Application H11-1056-25
Location Four Acres 36 Lime Walk Long Sutton
Proposal Details of construction method statement, assessment of risks posed by any contamination (including gases & water quality), detailed remediation scheme & Biodiversity Net Gain Plan (Conditions 3, 4, 5 & 10 of H11-0289-25)

Name Diane Gordon
Address SHDC Environmentla Protection

Project:	PROPOSED RESIDENTIAL DEVELOPMENT, LAND OFF LIME WALK, LONG SUTTON. PE12 9HG		
Drawing:	CONSTRUCTION MANAGEMENT PLAN		
Drawn:	DL	Date:	29.04.25
Status:	PLANNING	Scale:	1:500 @A1
Drawing Number:	LWLS-SH-PD-CMP-1020 A

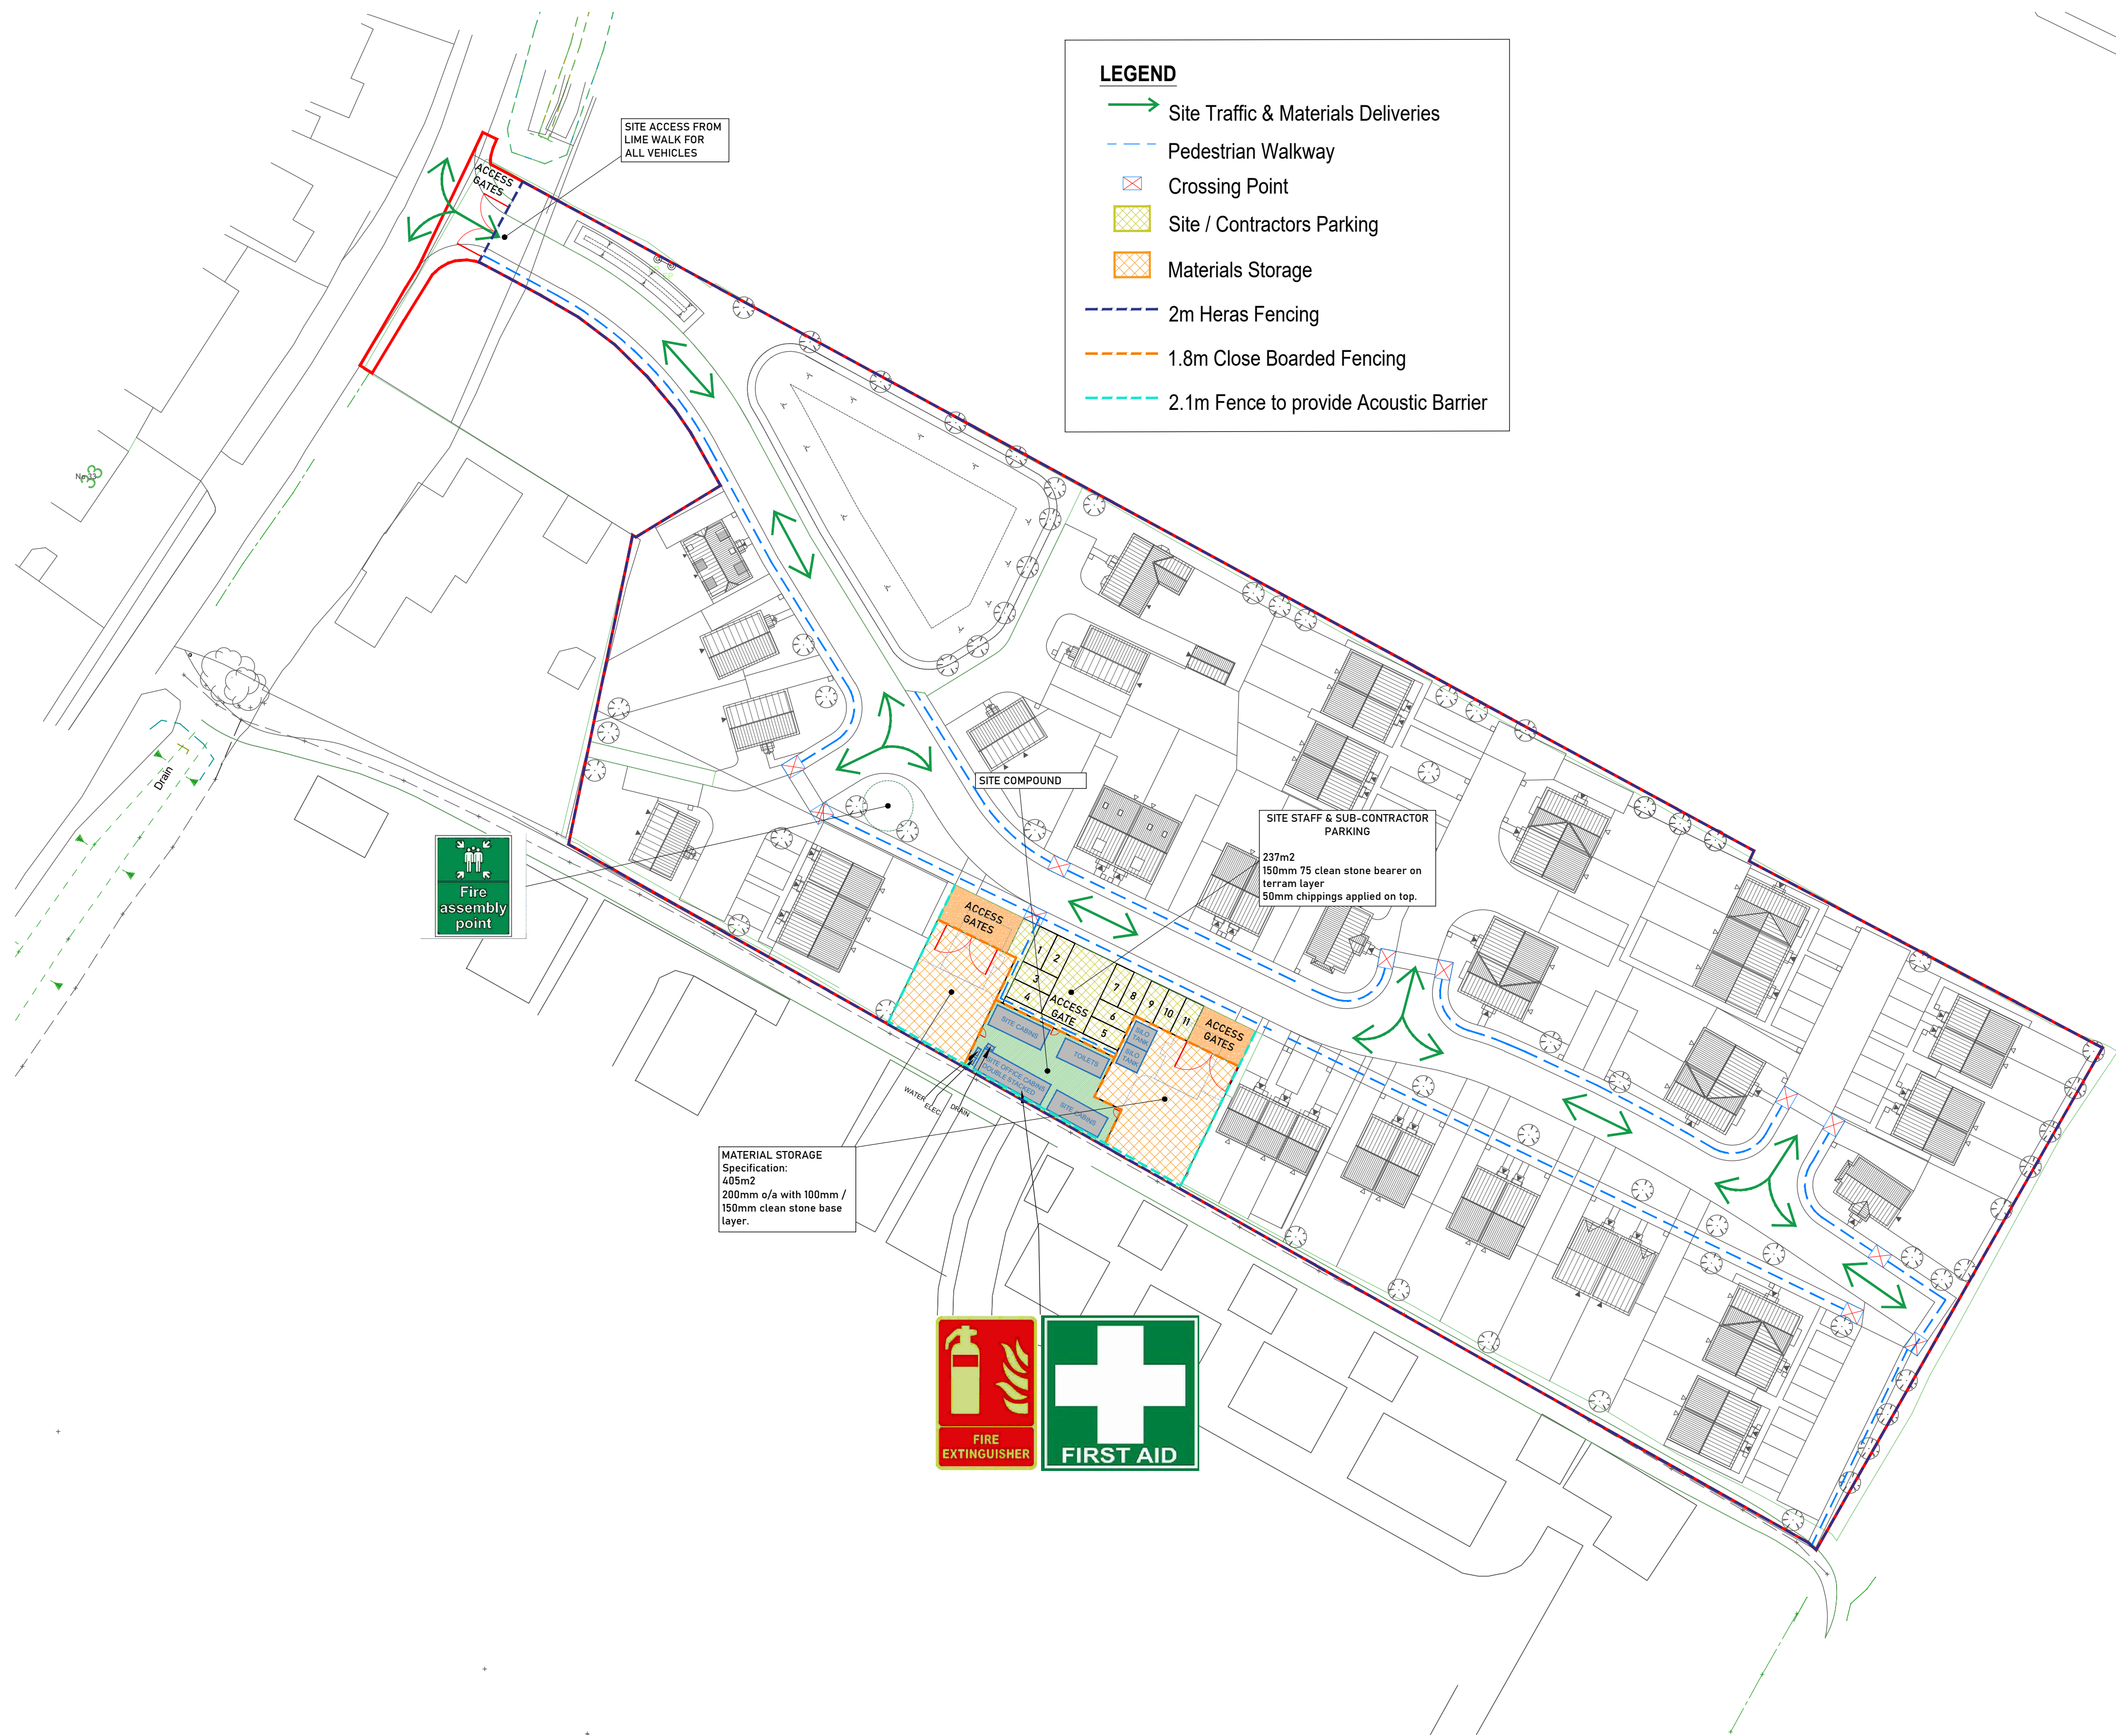
i would recommend 2m temporary hoarding be used around the rear and side boundaries of the site compound in order to protect the amenity of nearby properties
